KITITAS COUNTY
DEPARTMENT OF PUBLIC WORKS

MEMORANDUM

TO: Mackenzie Moynihan, Staff Planner, Community Development Services
FROM: Randy Carbary, Planner II *rc*
DATE: September 7, 2007
SUBJECT: Horse Jump Hill Short Plat

**HORSE JUMP HILL SHORT PLAT
 KITTITAS COUNTY SHORT PLAT NO. 07-113
 PORTION OF THE NE1/4, SEC. 32, T.20N., R.17E., W.M.
 KITTITAS COUNTY, WASHINGTON**

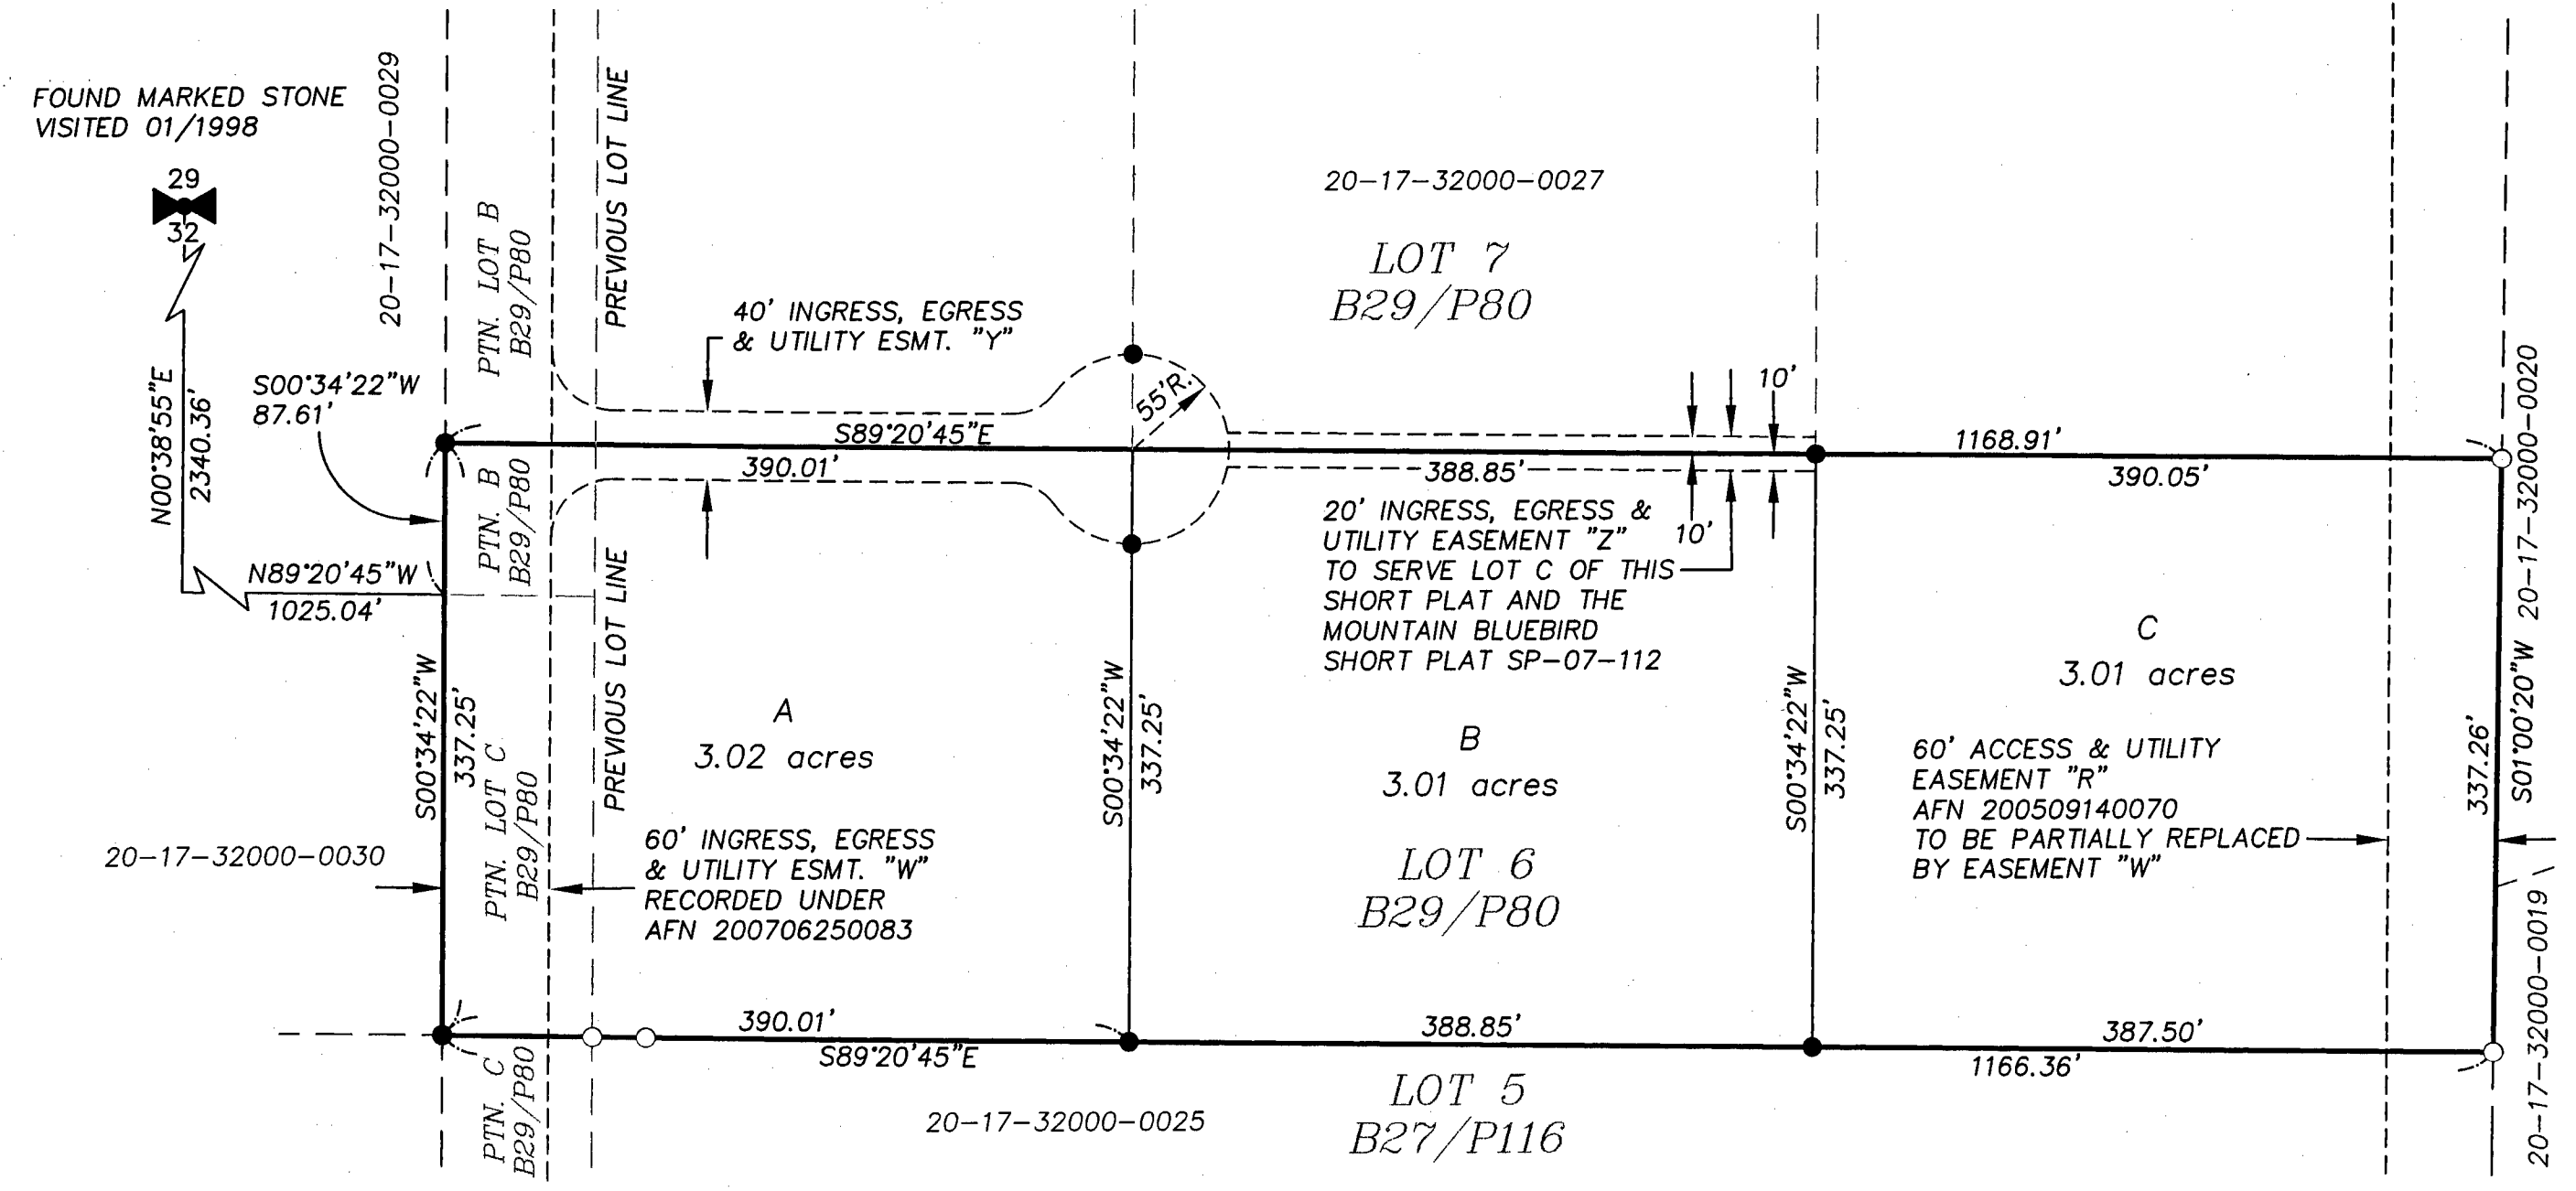
3. Private Road Improvements Access Easement "W": Access shall be constructed as a High-Density Private Road and serve no more than 40 tax parcels. See current Kittitas County Road Standards, 9/6/05 edition.

- a. Access easements shall be a minimum of 60' wide. The roadway shall have a minimum width of 22', with 1' shoulders, for a total width of 24'.
 - b. Minimum centerline radius shall be 60'.

- c. Surface requirement BST/ACP.
 - d. Maximum grade is 12%.
 - e. Stopping site distance, reference AASHTO.
 - f. Entering site distance, reference AASHTO.

- j. All easements shall provide for AASHTO radius at the intersection with a county road.
4. Access Easement "Y": Lots A and B shall be accessed via access easement "Y". Access shall be constructed to meet or exceed the requirements of a High-Density Private Road and serve no more than 14 tax parcels. See Kittitas County Road Standards, 9/6/05 edition.

- a. Access easements shall be a minimum of 40' wide. The roadway shall have a minimum width of 20', with 1' shoulders, for a total width of 22'.
 - b. Minimum centerline radius will be 60'.

- c. Surface requirement is for a minimum gravel surface depth of 6".
 - d. Maximum grade 8% flat, 12% rolling or mountainous.
 - e. Stopping site distance, reference AASHTO.

- j. All easements shall provide for AASHTO radius at the intersection with a county road.
5. Cul-de-Sac: Permanent dead-end streets shall have a turn-around having an outside right-of-way easement diameter of at least 110' (55' radius) at the closed end. See Kittitas County Road Standards, 9/6/05 edition.

- a. Cul-de-sac design, reference 2006 International Fire Code.
 - b. Contact the Fire Marshall regarding any additional cul-de-sac requirements.
 6. Access Easement "Z" Joint-Use Driveway: Lot C of the Mountain Bluebird Short Plat and C of the Horse Jump Hill Short Plat shall be accessed via access easement "Z". Access shall be constructed as a joint-use access and shall serve no more than two tax parcels. Access may be allowed to lot C via access easement "R" which is required to be constructed to a Low-Density Private Road standard. See Kittitas County Road Standards, 9/6/05 edition.

- a. Access easements shall be a minimum of 20' wide. The roadway width shall have a minimum width of 12'.
 - b. The surface requirement is for a minimum gravel surface depth of 6".
